City of Albuquerque

April 20, 2004

Re: Certification Submittal for Final Building Certificate of Occupancy for
Arno Lofts, [K-14 / D84]
400 Central Ave SE
Architect's Stamp Dated 04/19/04

ARNO LOFTS
GRADING,
DRAINAGE, &
UTILITY PLAN

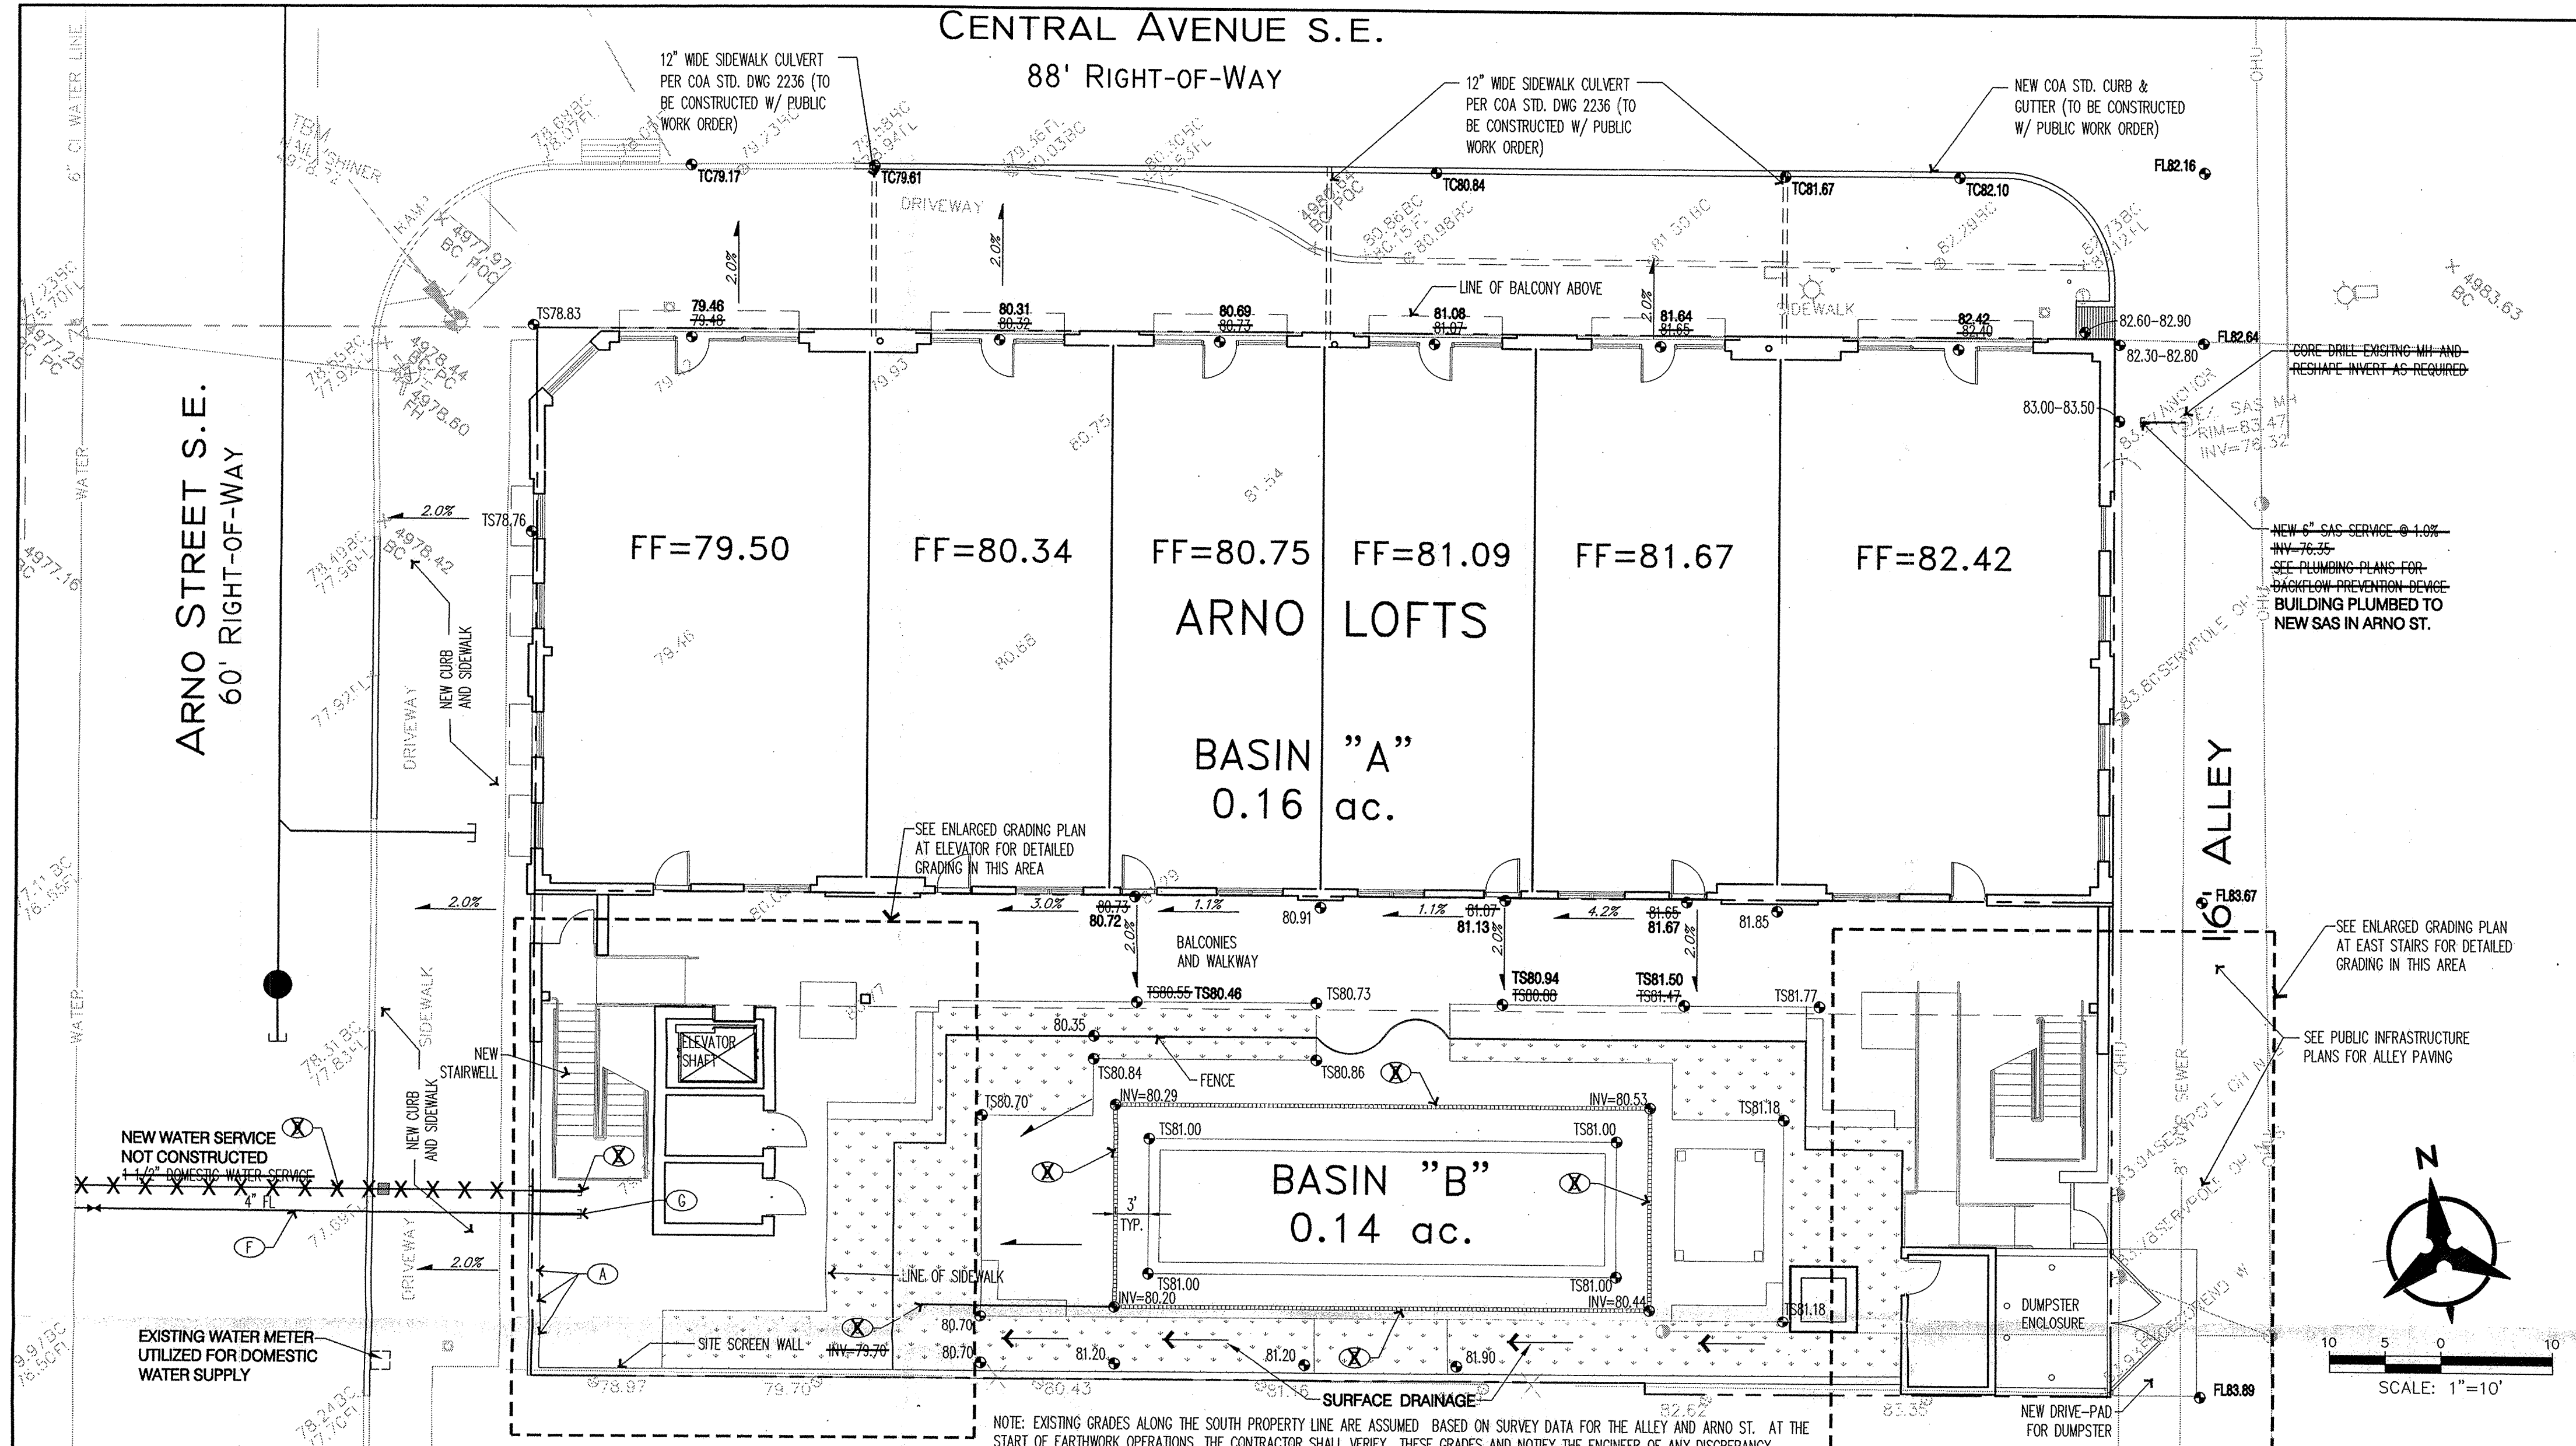
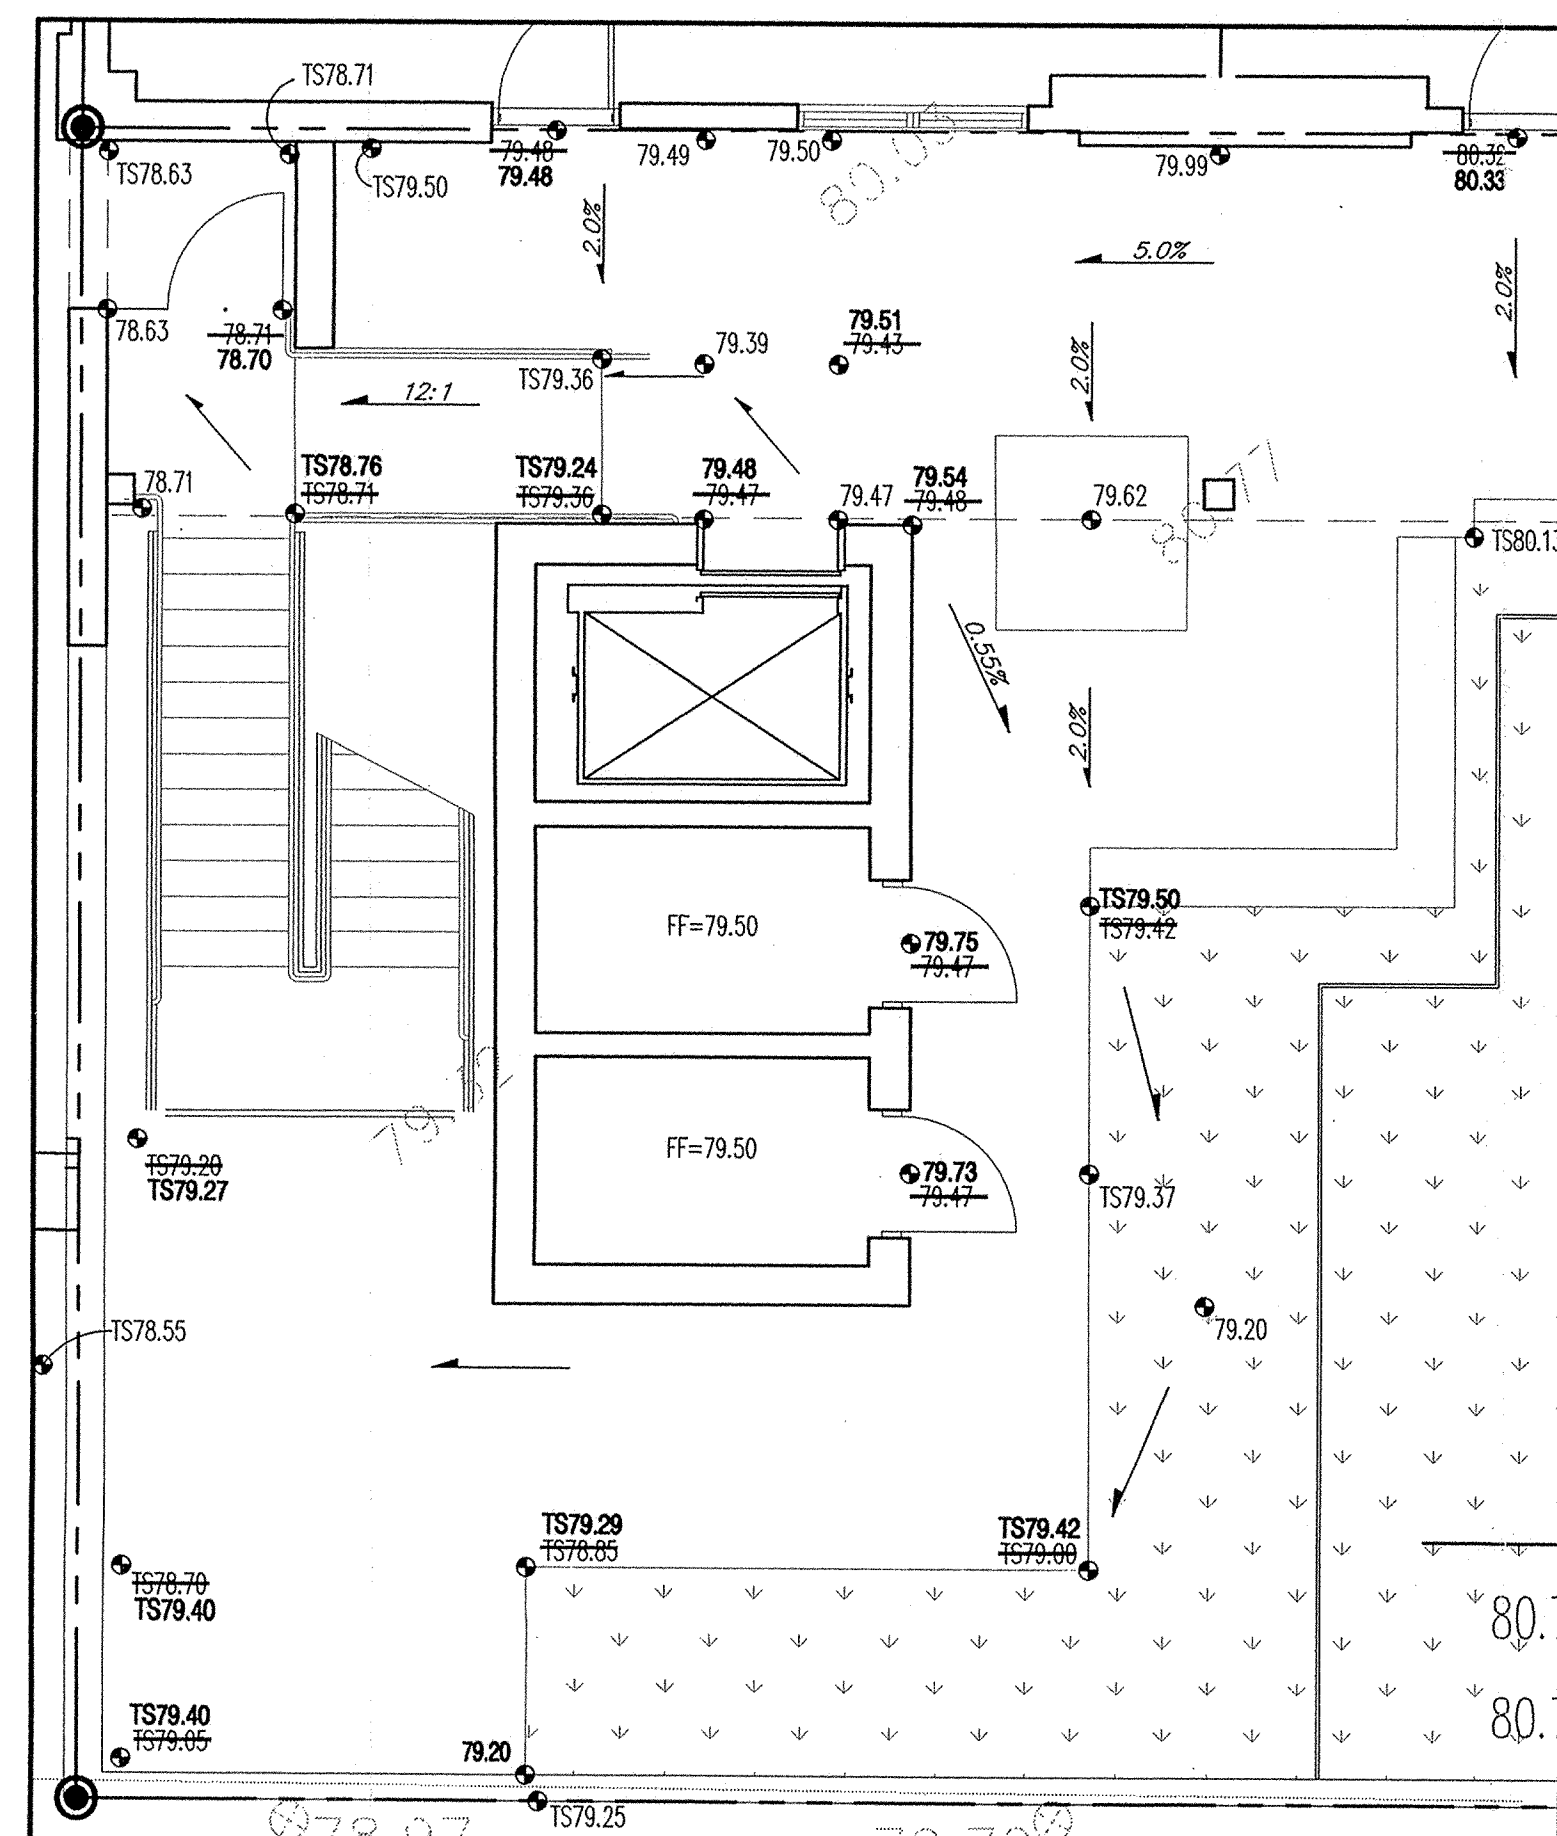
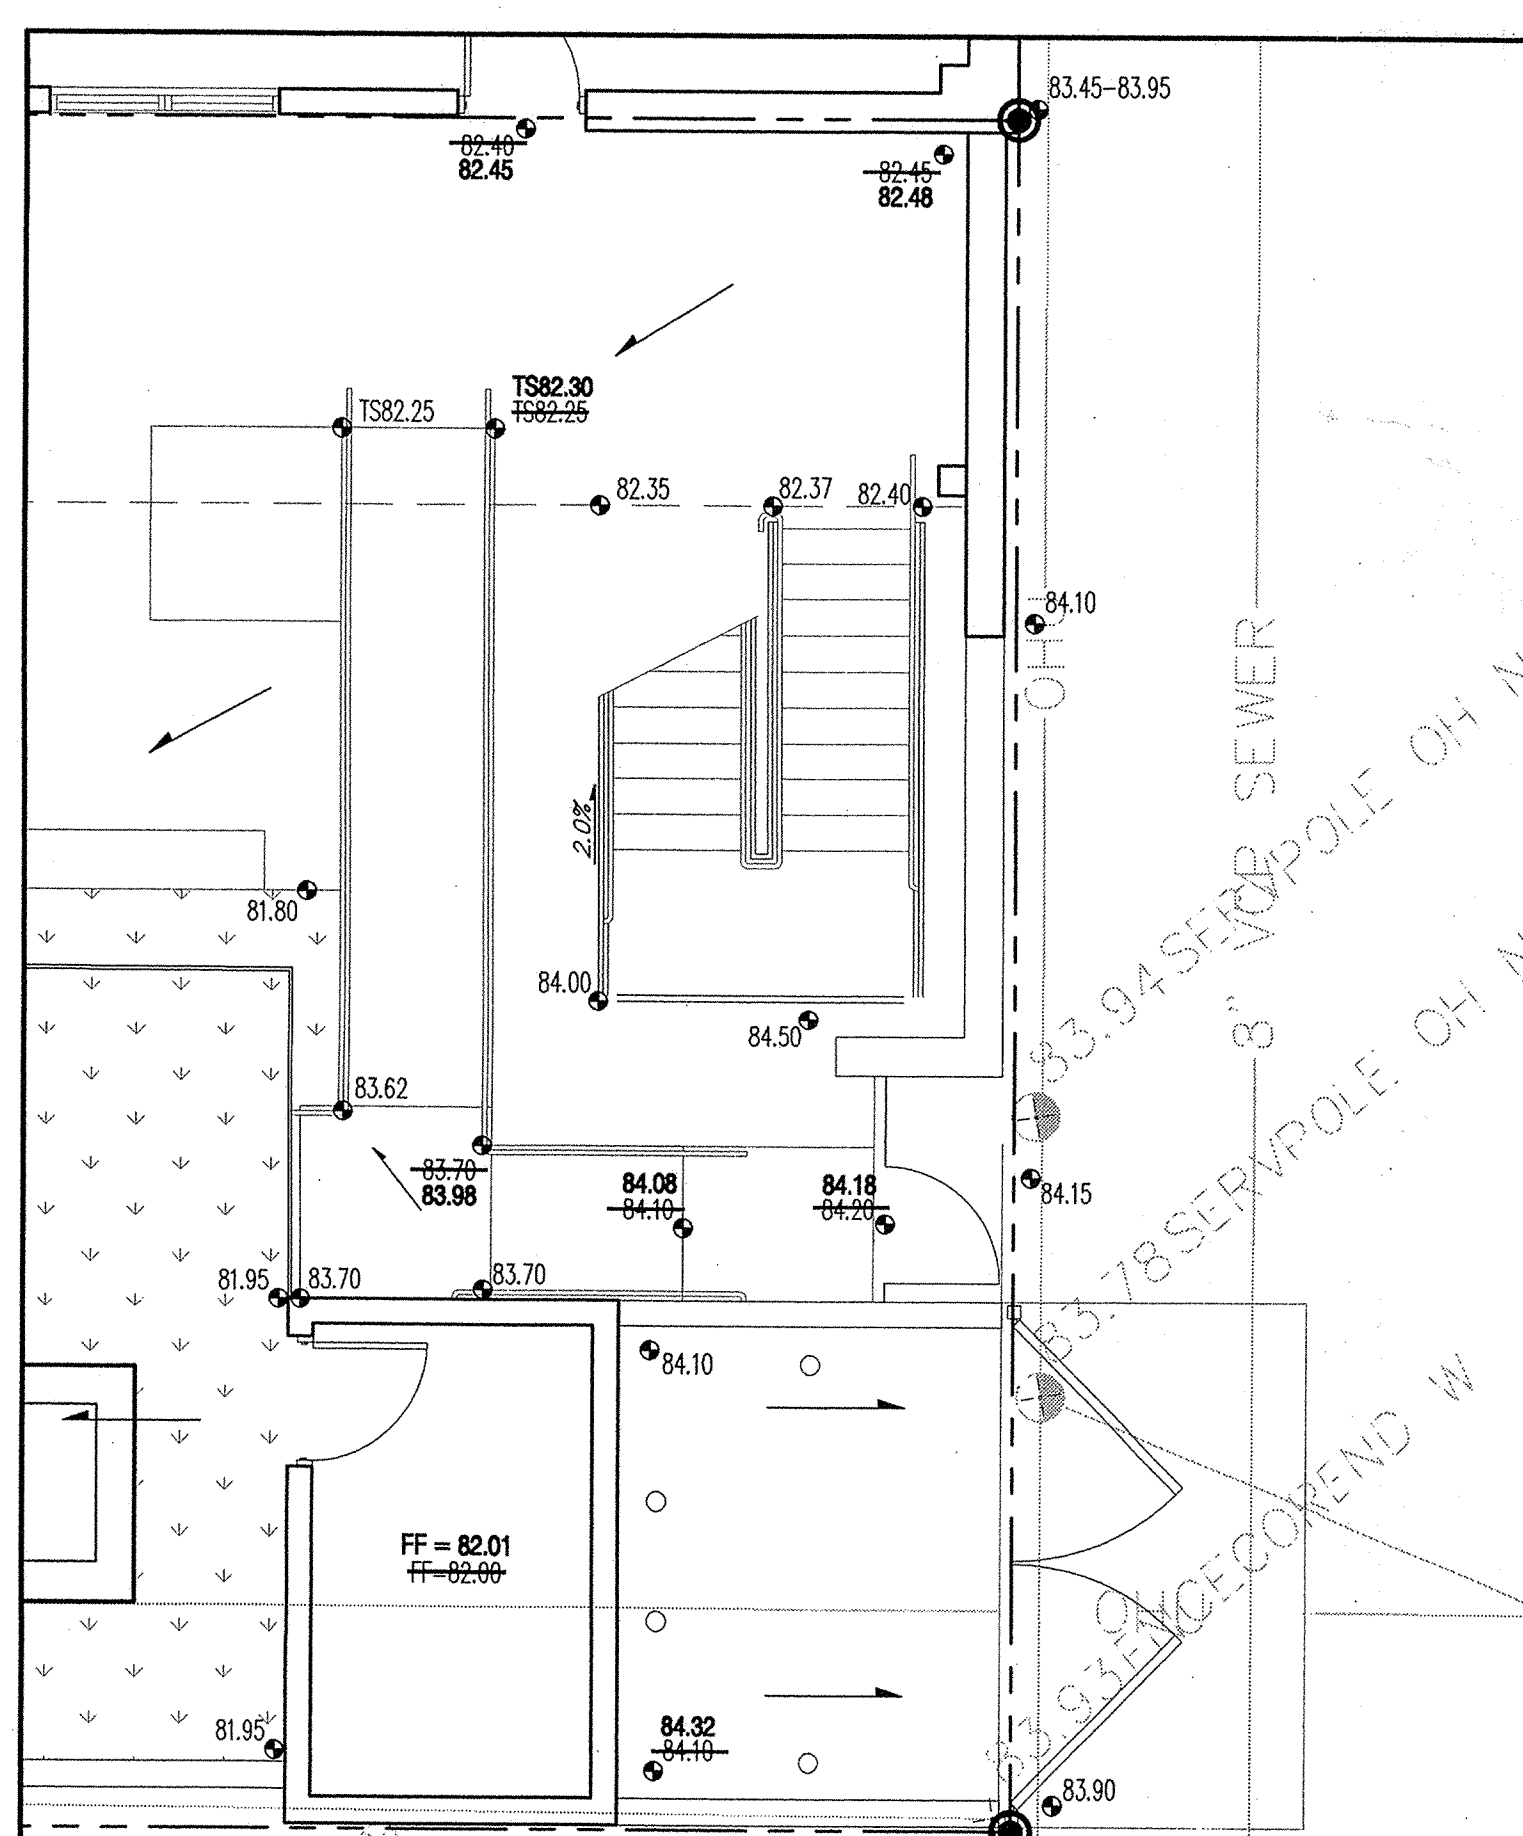
The TCL / Letter of Certification submitted on April 19, 2004 is not sufficient for acceptance by this office for final Certificate of Occupancy (C.O.). Upon field inspection, it was found that the proposed frontage of Central construction is not completed and has not been accepted by the City, as well as the alleyway construction adjacent to lofts. Please provide original signature on letter of Certification for next submittal.

The TCL (or DRB Site Plan) submitted for Final C.O. needs to be the exact copy of the approved TCL in the plan set approved for building permit. This will be the latest edition, which may have redlined comments, initialled and dated by the designer-of-record.

Resubmit acceptable package along with fully completed Drainage Information Sheet to front counter personnel for log in and evaluation by Transportation.
